Please upload the revised attached plans from the applicant onto Ocella for BN/85/19/DOC. I have attached the Action Sheet.

Subject: RE: BN/85/19/DOC - The Lillies
Importance: High

I have received the email below from the applicant for BN/85/19/DOC at the Lillies, Yapton Road in Barnham.

TYPICAL CROSS SECTION ACROSS PERMEABLE BLOCK PAVED DRIVES INCORPORATING IMPERMEABLE BLOCK PAVED SERVICE CORRIDOR

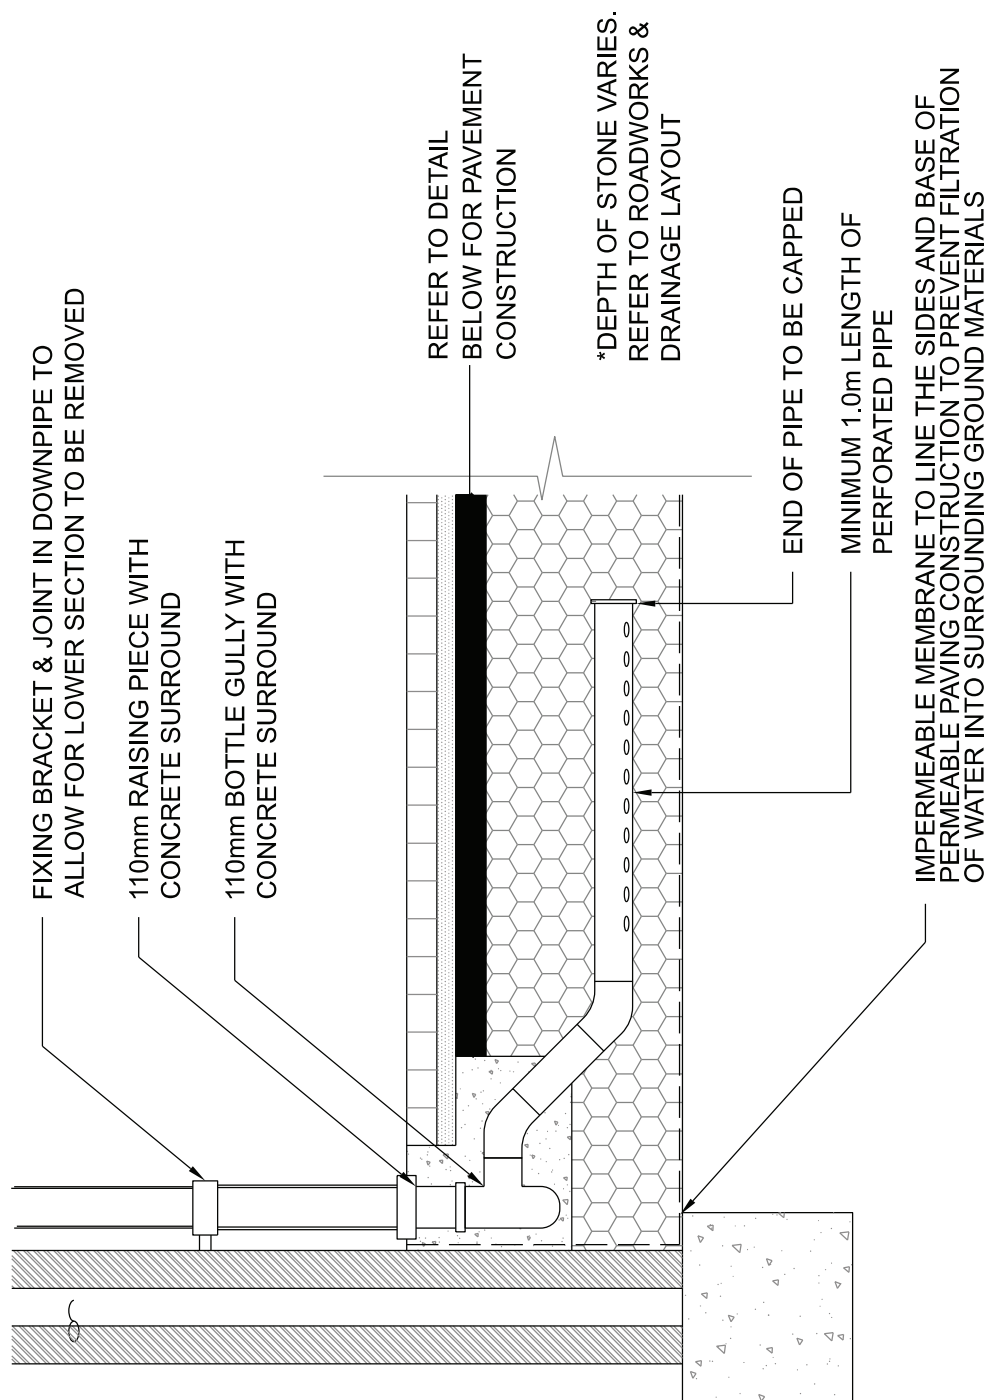
11. Make sure all RWP's are shown clearly ie. thicken lines. Line style adjusted.
12. Where the existing public foul sewer gravity sewer and rising main passes beneath the permeable pavements, are you proposing the service corridor construction arrangement – If so, detail how water can flow between the separate sub bases. Detail added.

11. Make sure all RWP's are shown clearly ie. thicken lines. This is not within the remit of the LLFA. Disagree
12. Where the existing public foul sewer gravity sewer and rising main passes beneath the permeable pavements, are you proposing the service corridor construction arrangement – If so, detail how water can flow between the separate sub bases. No. These features pass beneath the permeable paving construction. Yes the sewer below is appreciated but is the backfill above the sewer permeable construction? Provide a detail.

SFA10C Althon Pre-Cast Headwall

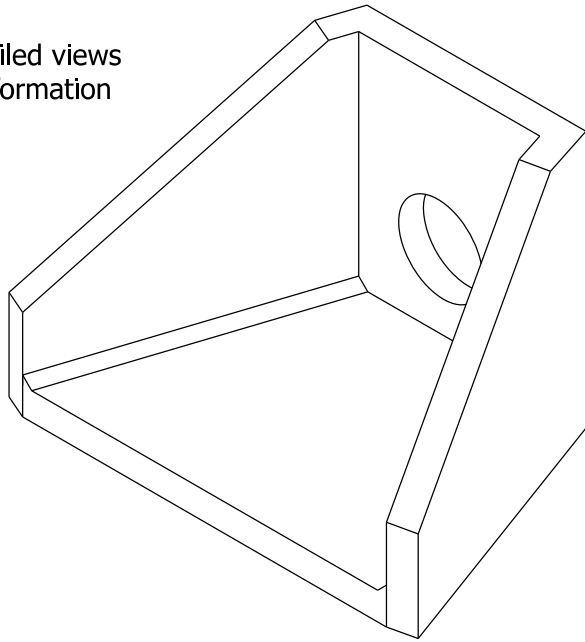
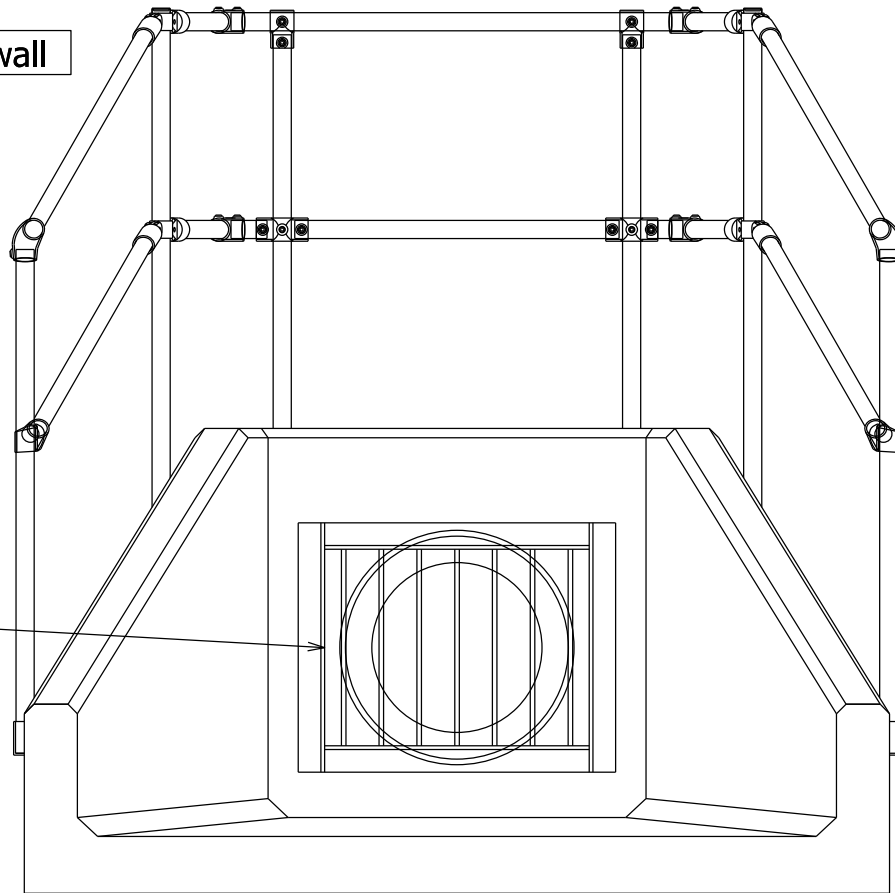
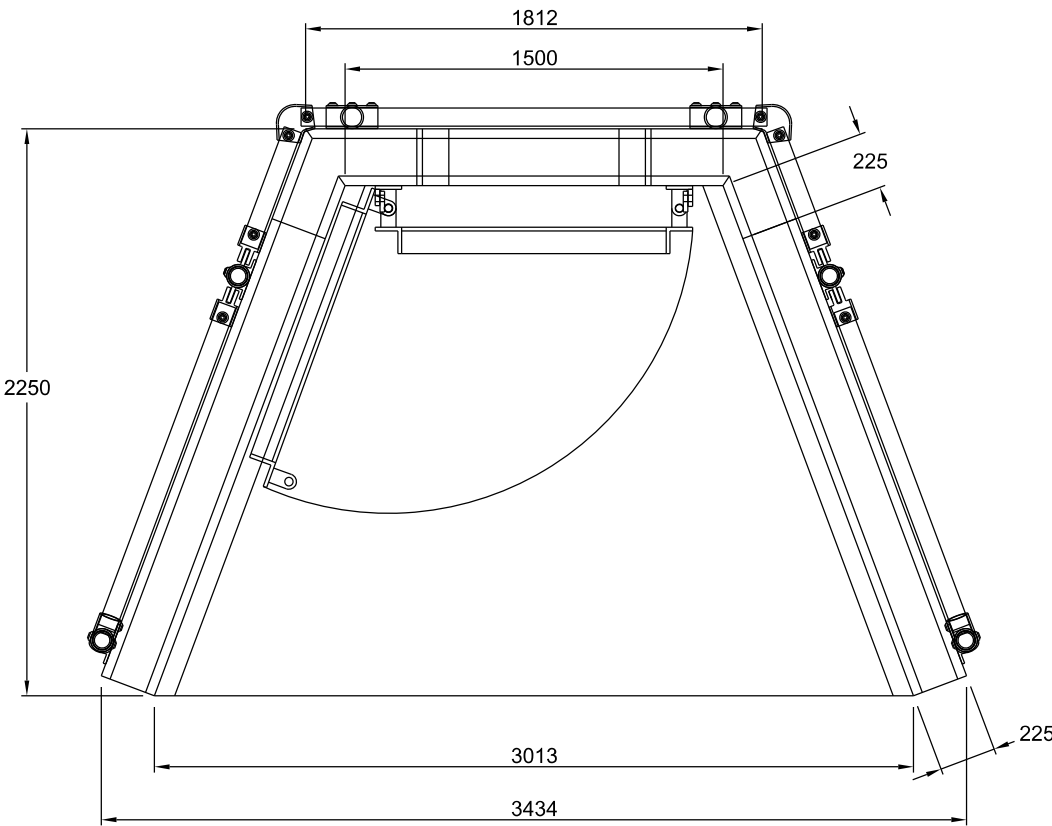
27. Headwall SFA10A incorrectly specified for the pond headwall – this should be SFA10C and SFA10A specified for the discharge to the ditch. Adjusted
28. Pond headwall – specify a 'cranked' grille to suite a 450mm pipe. Banks in vicinity of headwall to be profiled to suit wing walls – add note. Added

27. Headwall SFA10A incorrectly specified for the pond headwall – this should be SFA10C and SFA10A specified for the discharge to the ditch. This is not within the remit of the LLFA. This is a s104 matter It also considered part of the remit of the LPA.

28. Pond headwall – specify a 'cranked' grille to suite a 450mm pipe. Banks in vicinity of headwall to be profiled to suit wing walls – add note. This is not within the remit of the LLFA. This is a s104 matter It also considered part of the remit of the LPA.

ARUN DISTRICT COUNCIL BN801500C

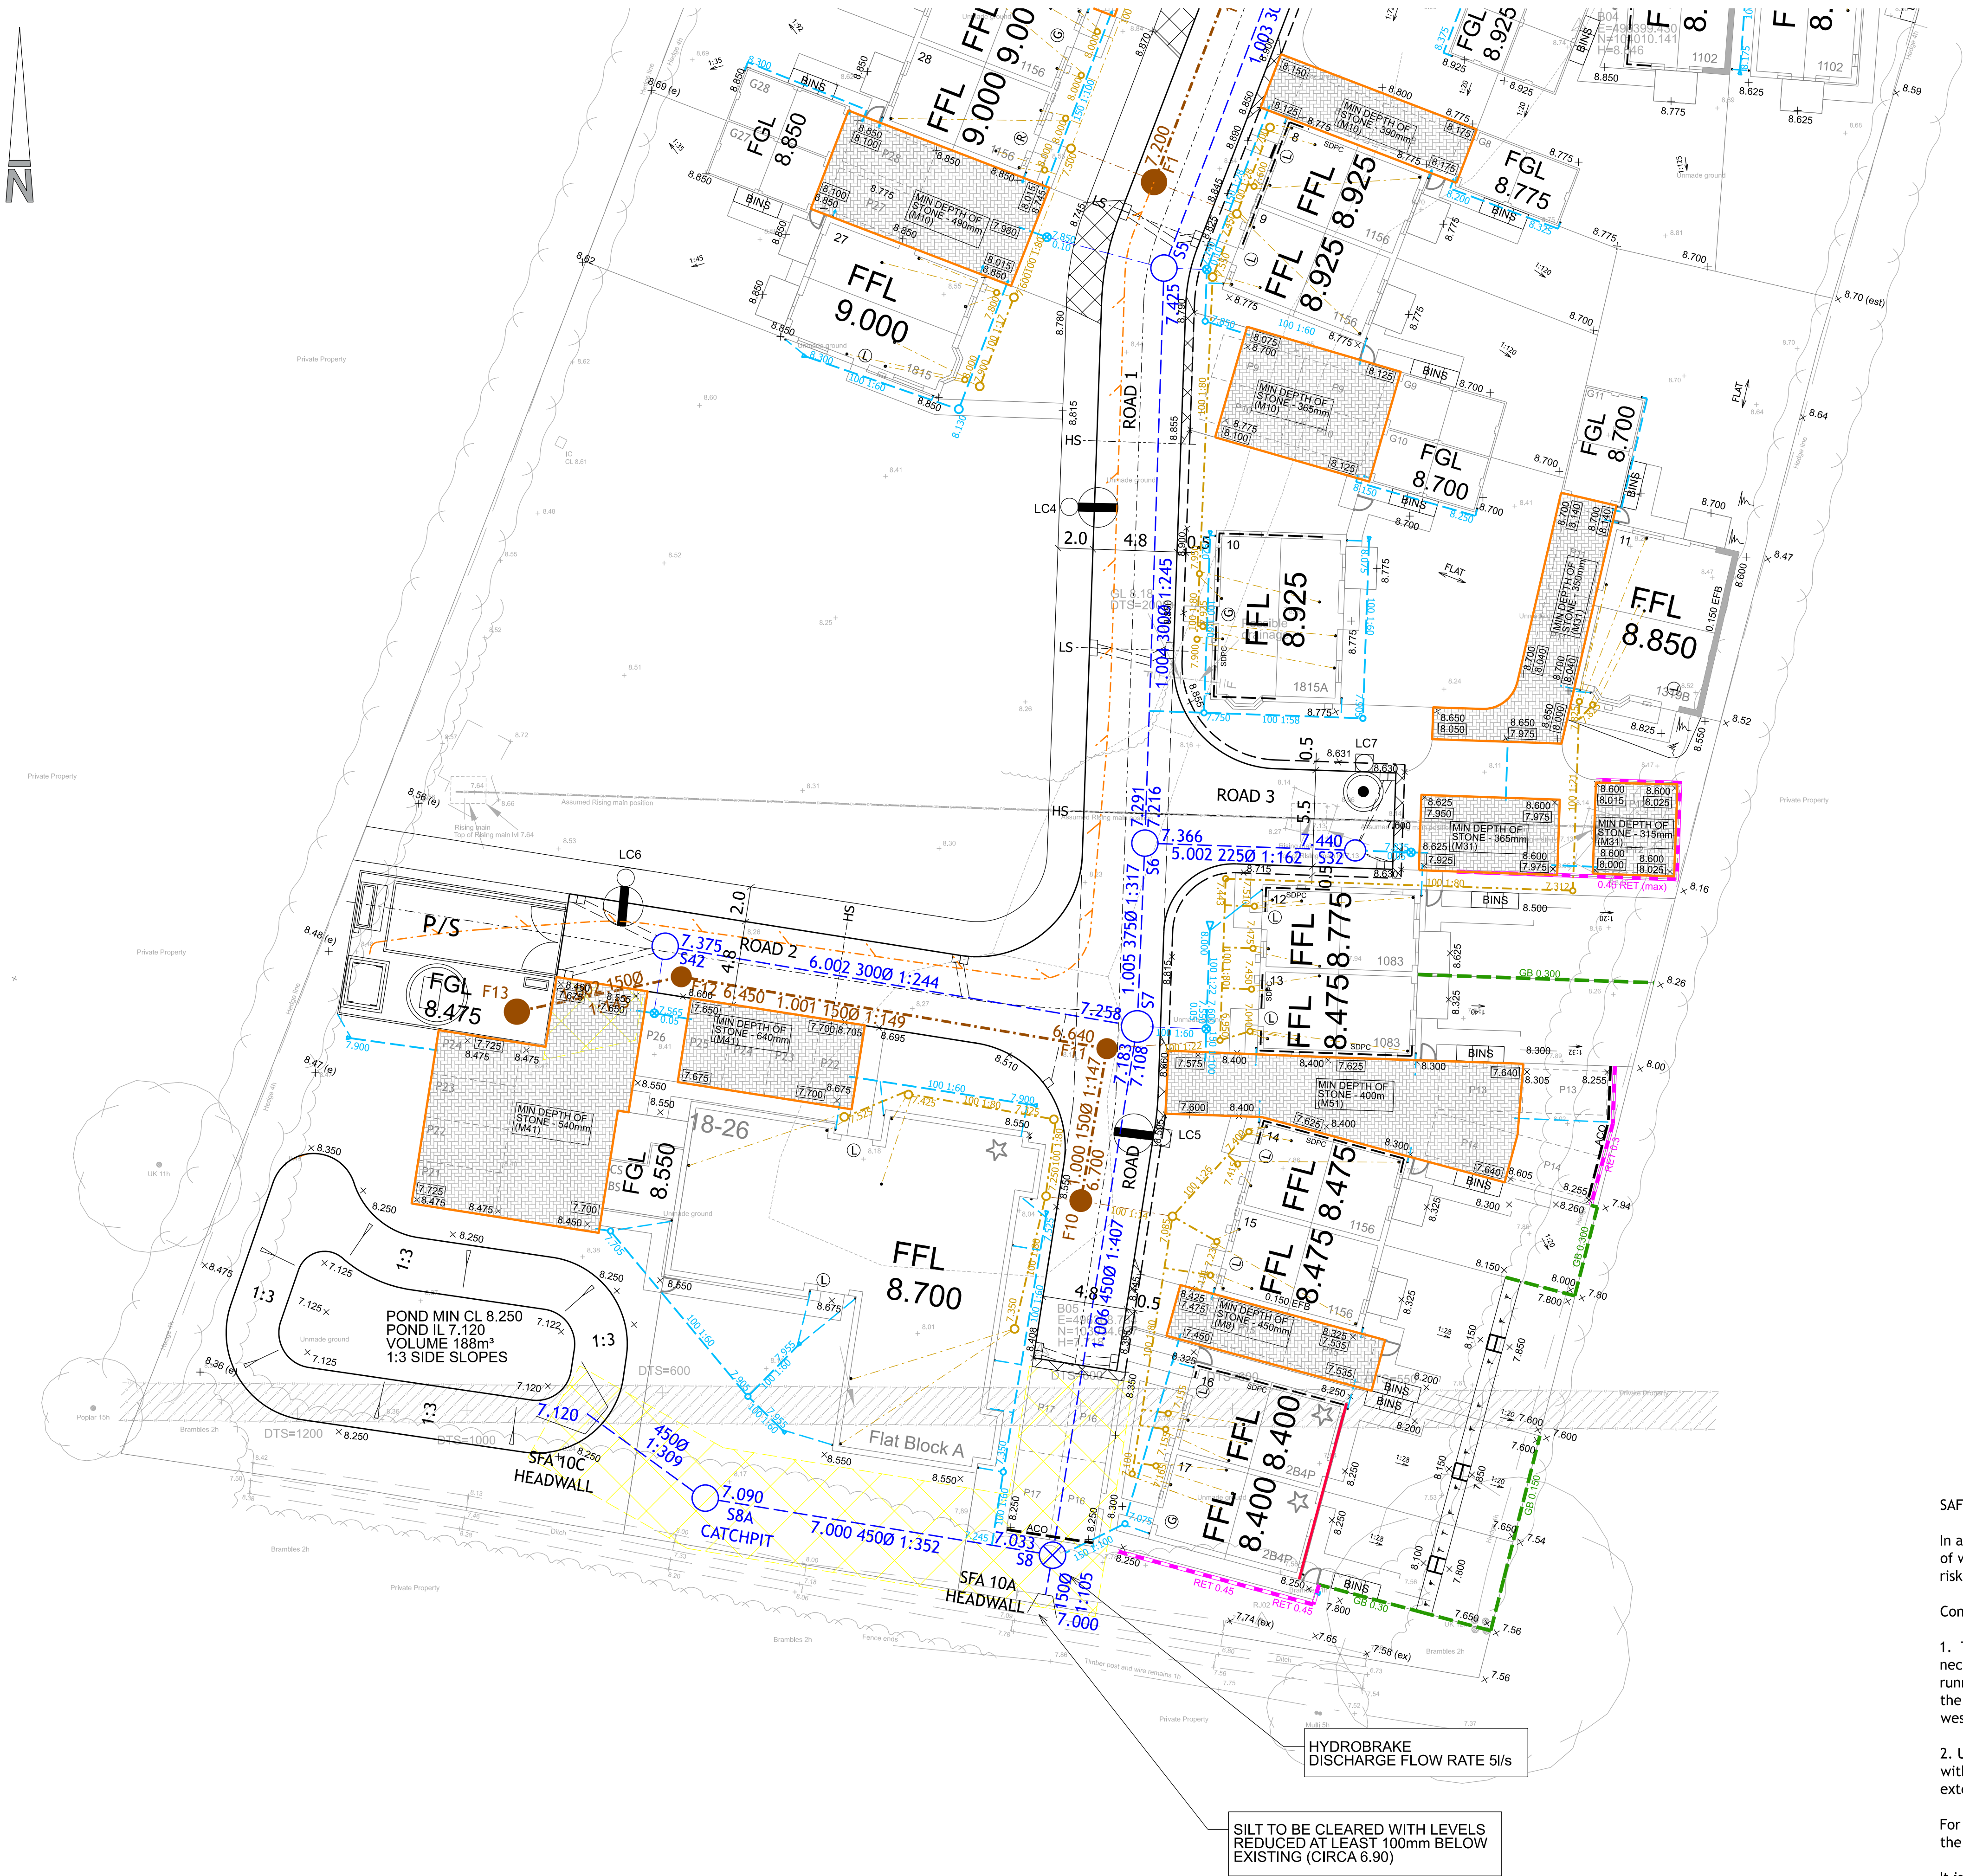
2. The top of bank of the proposed pond needs to be kept at least 3 metres away from the top of the bank of the ditch to allow maintenance access and comply with our land drainage byelaws. Pond position adjusted to suit comments

3. The path (assumed to be unfenced) for plot 17 appears to be within 3m of the top of the bank of the ditch. Since this encroaches into 3m working width for machinery required for ditch clearance, please confirm that the path will be designed to accept loadings from suitable machinery and that it will not be fenced off. Add notes to drawing. *Noted.*

4. The ground slope adjacent to plot 17 will prevent safe access for maintenance – please rectify. *Adjusted to suit.*
5. Southern Water requires the pond to be located at least 5m away from the proposed pumping station. It is unclear as to whether this has been achieved. *Adjusted to suit.*

8. Manhole adjacent plot 38 – invert level missing. Adjusted.
9. Permeable pavement between plot 36 and 37 – outlet arrangement is not clear. Adjusted.
10. Link pipes between permeable pavements – specify diffuser units at each end, pipe inverts and diameters. As per comment on point 6.

20. Manhole downstream of permeable paving adjacent plot 12 – specify invert level. Added
21. All connections not made to manholes to connect via oblique 45 degree junctions – add note. Note added

22. ACO drain adjacent plot 38 – indicate purpose/connectivity. Line style adjusted
23. ACO drain near hydrobrake chamber – show connectivity. Line style adjusted

33. Specify invert level on drawing where discharging to the ditch. We need to achieve as much freeboard as possible between ditch bed and pipe invert – at present this is insufficient. Please investigate lifting the pipe invert and/or regrading the ditch. Note added to drawing

2. The top of bank of the proposed pond needs to be kept at least 3 metres away from the top of the bank of the ditch to allow maintenance access and comply with our land drainage byelaws. As we have always stated. That the ditch can be maintained from the basin. Disagree. The top of the basin banks needs to be 3m away from the top of the ditch bank to ensure ease of future maintenance.

3. The path (assumed to be unfenced) for plot 17 appears to be within 3m of the top of the bank of the ditch. Since this encroaches into 3m working width for machinery required for ditch clearance, please confirm that the path will be designed to accept loadings from suitable machinery and that it will not be fenced off. Add notes to drawing. Noted.

4. The ground slope adjacent to plot 17 will prevent safe access for maintenance – please rectify. I assume this will be dealt with.
5. Southern Water requires the pond to be located at least 5m away from the proposed pumping station. It is unclear as to whether this has been achieved. We are awaiting a formal response from Southern Water in relation to this. However, as the attenuation basin is largely dry and also lined there is no interaction between these two features. This is purely a matter for southern water.

8. Manhole adjacent plot 38 – invert level missing. This is a private manhole – this is not a reason to hold discharge of the condition. Disagree, this part of the design.

9. Permeable pavement between plot 36 and 37 – outlet arrangement is not clear. The drawings show a connecting pipe, Make it clearer.
10. Link pipes between permeable pavements – specify diffuser units at each end, pipe inverts and diameters. These are 150dia pipes – a diffuser unit is not necessary and not within the remit of the LLFA. Disagree

22. ACO drain adjacent plot 38 – indicate purpose/connectivity. To drain parking bays. The connection is shown on the drawings. Show more clearly
23. ACO drain near hydrobrake chamber – show connectivity. This is not within the remit of the LLFA. The connection is shown on the drawings. Disagree

33. Specify invert level on drawing where discharging to the ditch. We need to achieve as much freeboard as possible between ditch bed and pipe invert – at present this is insufficient. Please investigate lifting the pipe invert and/or regrading the ditch. The ditch ILs shown are the silted bed. Once cleared of silt these levels are expected to be circa 100mm lower. Specify the desilted levels on the drawing.
